**Our ref:** WA/2018/124752/01-L01  
**Your ref:** 17/02534/OUT  
**Date:** 29 January 2018

**The construction of a business park of up to 60,000 sq.m (GEA) of flexible class B1(a) office / class B1(b) research & development floorspace; parking for up to 2,000 cars; and associated highways, infrastructure and earthworks**

**Land north of Bicester Avenue Garden Centre, Oxford Road, Bicester**

Drawing Number
1105_P_005

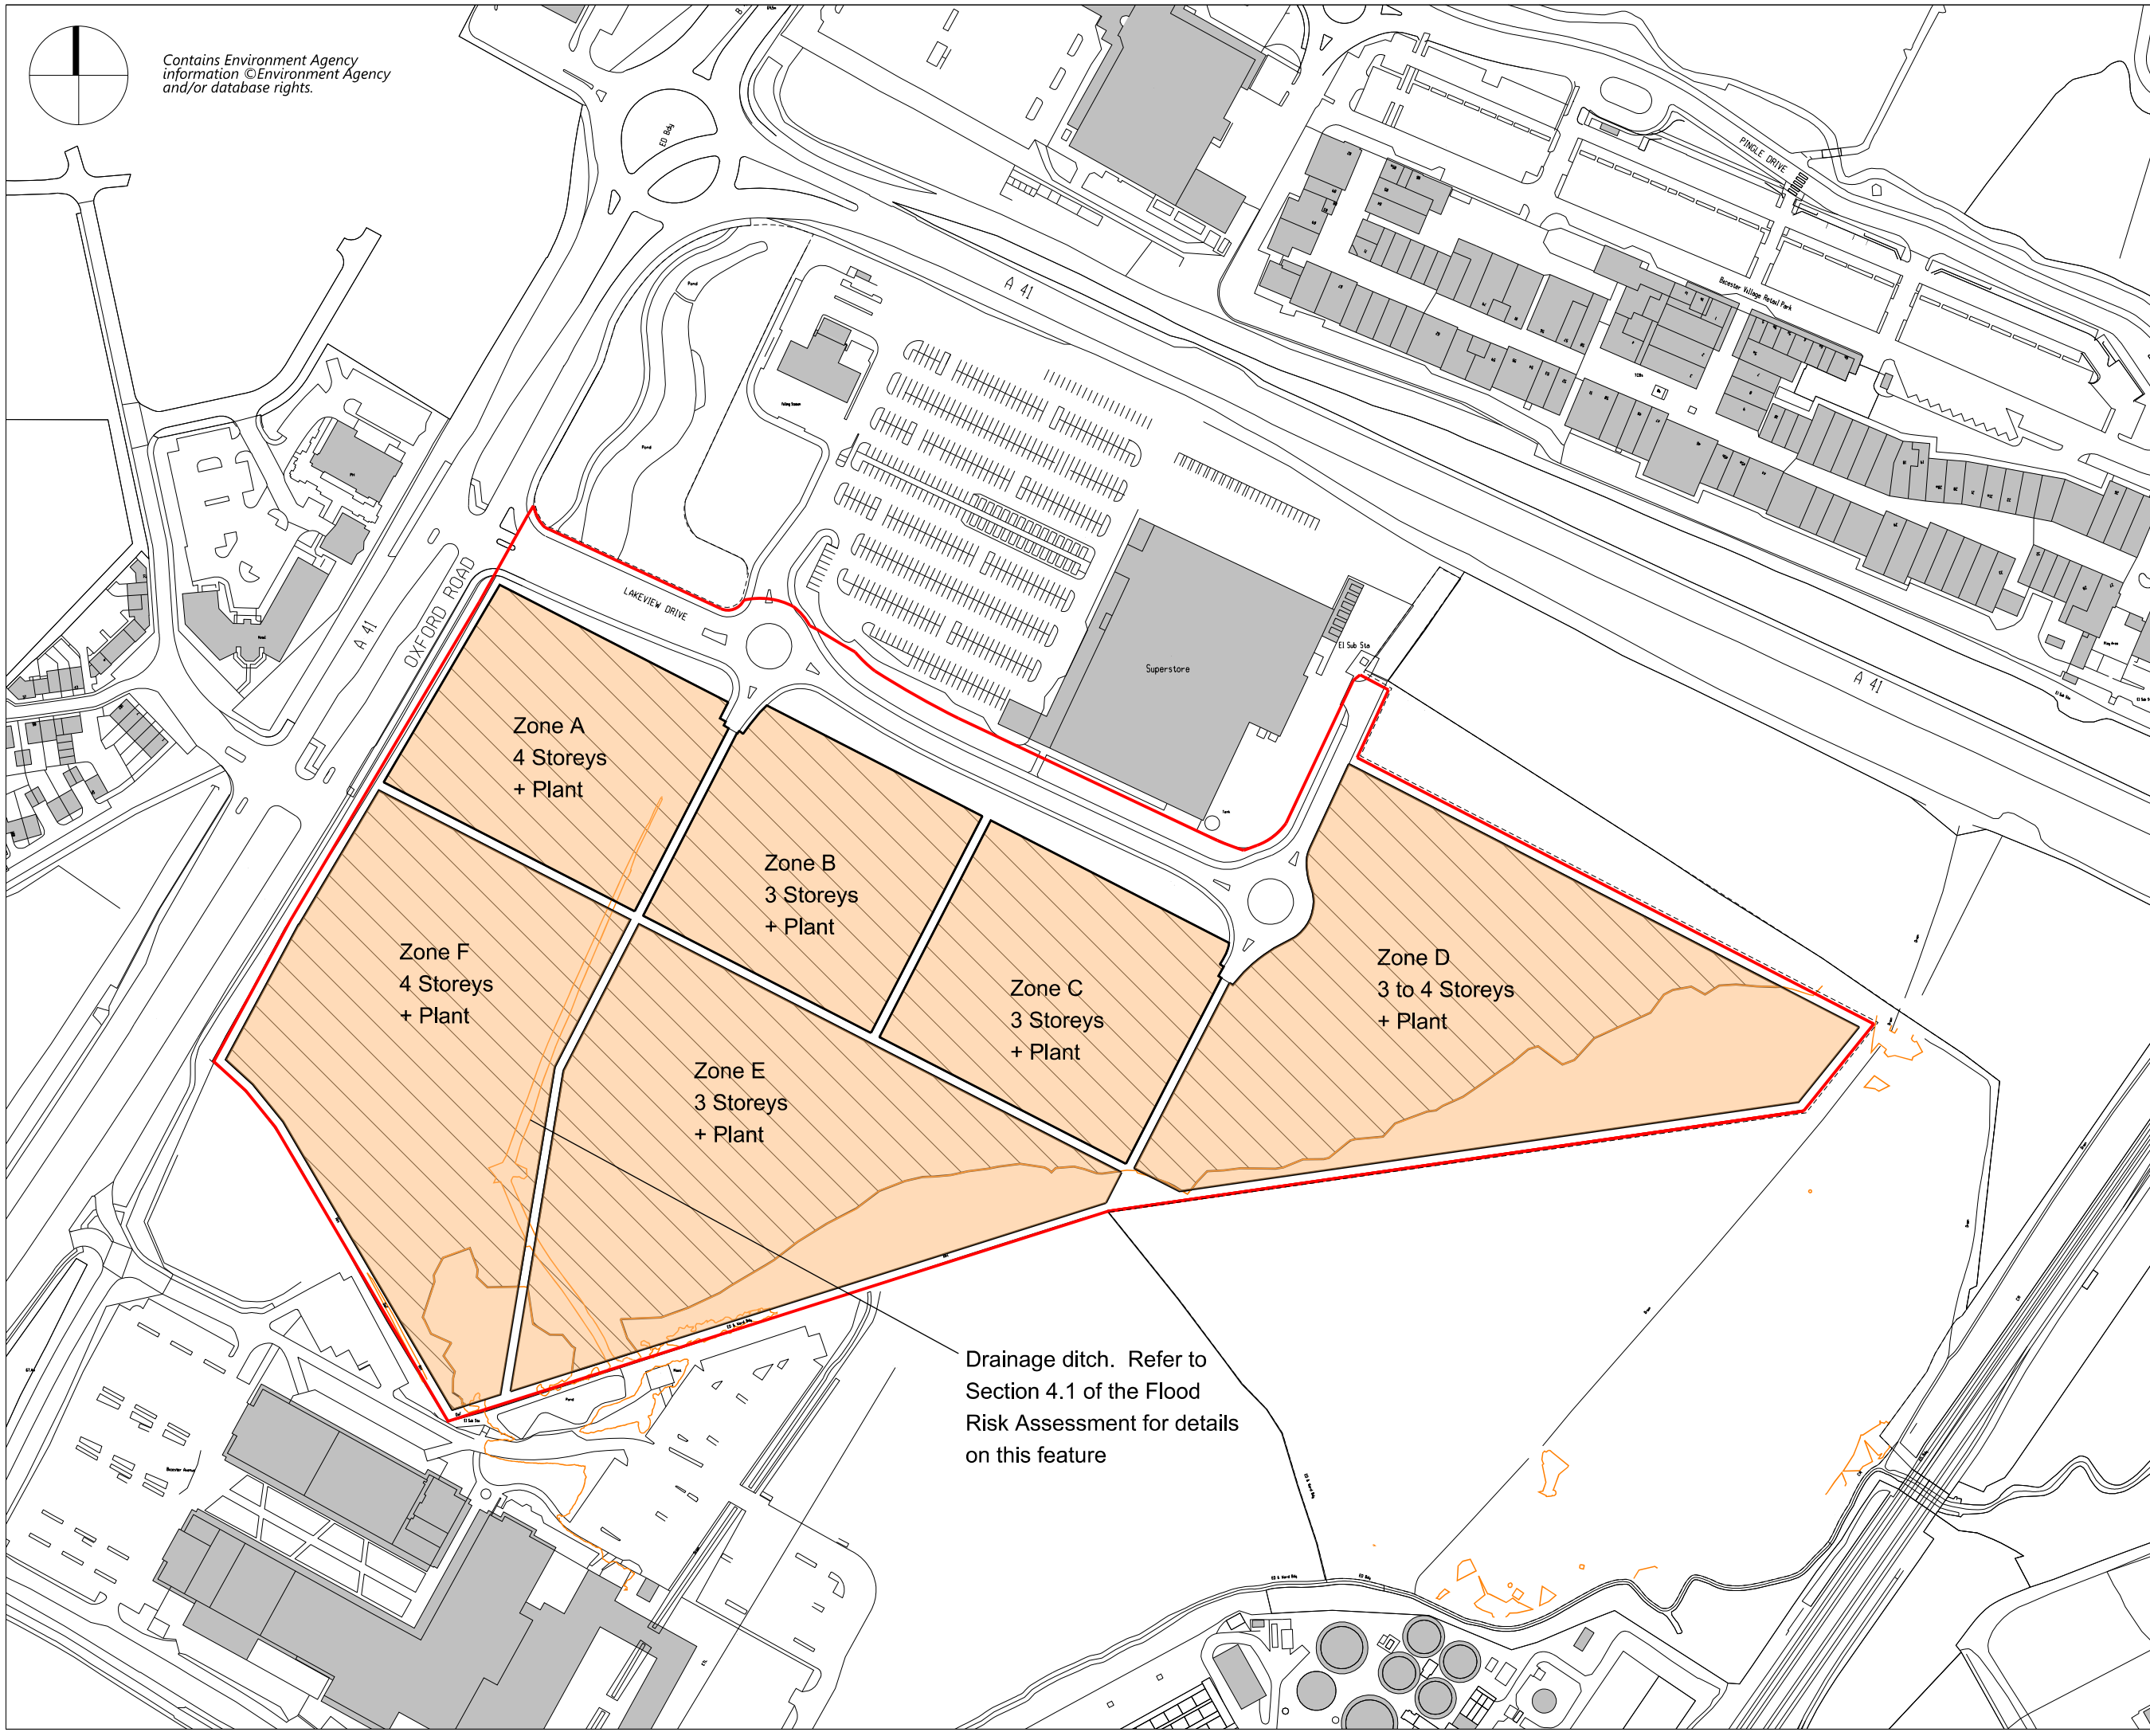
- Buildings will be located outside the 1 in 100 year including 35% climate change allowance flood extent.
- There shall be no raising of existing ground levels in the functional flood plain.
- Finished floor levels at a minimum of 300mm above the 1 in 100 year flood level including 35% allowance for climate change.

Walls and fences can have a significant impact on the flow and storage of flood water, especially if they are constructed across a flood flow route. This can lead to higher levels of flood water on the upstream side of the fence or wall which will potentially increase the flood risk to nearby areas. Therefore walls and fences should be permeable to flood water.

We recommend the use of post and rail fencing, hit and miss fencing (vertical slats fixed alternately on each side of horizontal posts) or hedging. If a solid wall is proposed there must be openings below the 1% annual probability (1 in 100) flood level with an appropriate allowance for climate change to allow the movement of flood water. The openings should be at least 1 metre wide by the depth of flooding and there should be one opening in every 5-metre length of wall.
